**KIRKLEES METROPOLITAN COUNCIL
INVESTMENT & REGENERATION SERVICE**

DELEGATED DECISION TO DETERMINE PLANNING APPLICATIONS

Reference No:	2023/62/93209/W
Site Address:	173, Moor Lane, Netherton, Huddersfield, HD4 7JN
Description:	Erection of two storey rear extension and associated alterations
Recommending Officer:	Molly Storer

HOUSEHOLDER DELEGATED REPORT

REAR ELEVATION_
AS PROPOSED
Scale 1:100

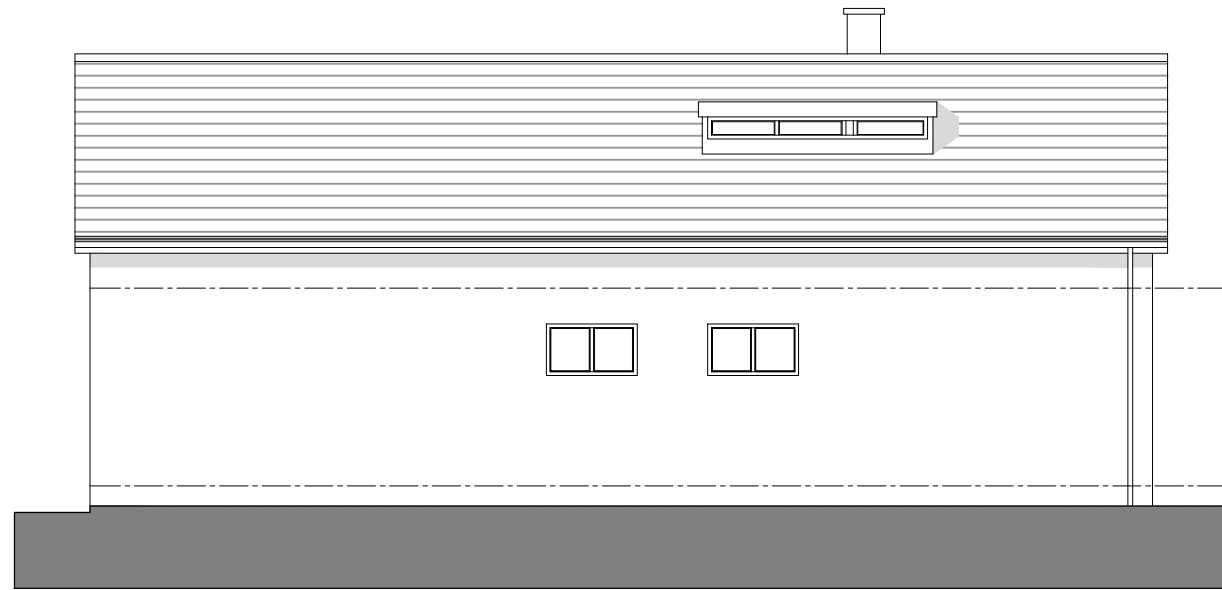
YES / NO	SUMMARY
Negotiations/Amendments during course of application	Yes	The agent was contacted over concerns with the size of the window in the rear elevation with regards to the overlooking it may cause to Bourn View Road. The agent responded with amended plans which showed an obscured glazed balustrade on this window which would be 1.1m in height. Whether this has overcome the concerns will be discussed later on in the report
Parish/Town Council comments sought	No	
Planning History	No	
Consultations required	No

Facing materials and detailing	• KDP 9 of the SPD • Policy LP24 Design (d) (iii) of the KLP • Chapter 12 of the NPPF	Materials to match – red facing brick, white cladding panels and concrete interlocking tiles.	✓
Roof style	• KDP 1 and 2 of the SPD • Policy LP24 Design (a), (c) and (d) of the KLP • Chapter 12 of the NPPF	The gable roof design would follow on from the original roof causing limited visual harm.	✓
Window proportions	• KDP 1 and 2 of the SPD • Policy LP24 Design (a), (c) and (d) of the KLP • Chapter 12 of the NPPF	The west facing elevation will include one extra window to match the existing one present on this elevation. The east facing elevation will also have an additional window to match the existing one present on this elevation and a roof light located on the roof slope. The north elevation will have patio doors windows and a smaller window located on the ground floor and a large three panel window on the first floor however this will have an obscured glazed balustrade/panel 1.1m in height. These will be framed in matching UPVC. The feature first floor window is not a common feature in the area but, with the obscure panel, is considered acceptable on balance.	✓

Relevant key design principle (KDP) of the SPD, Policy in the Kirklees Local Plan and the NPPF	Further comments	✓ / X / N/A
Impact on privacy of neighbours (to sides, rear and front)	• KDP 3 & 4 of the SPD • Policy LP24 Design (d) (iv) • Chapter 12 of the NPPF	Due to the addition of the obscured glazed balustrade the perceived impact on No.182 would be significantly limited and there is no direct line of sight into habitable windows or rear garden area. With regard to No.171, limited openings and facing onto non habitable rooms mean there won't be significant harm caused to this property in relation to privacy. Distance to no. 209 not reduced.	✓
Impact on light and outlook of neighbours (to sides, rear and front)	• KDP 4, 5, 6 of the SPD • Policy LP24 Design (b) • Chapter 12 of the NPPF	Due to the orientation of the properties No.171 may experience some shadowing in the early hours in summer months however this is not considered reason for refusal. The side facing panels in the conservatory to the rear	✓
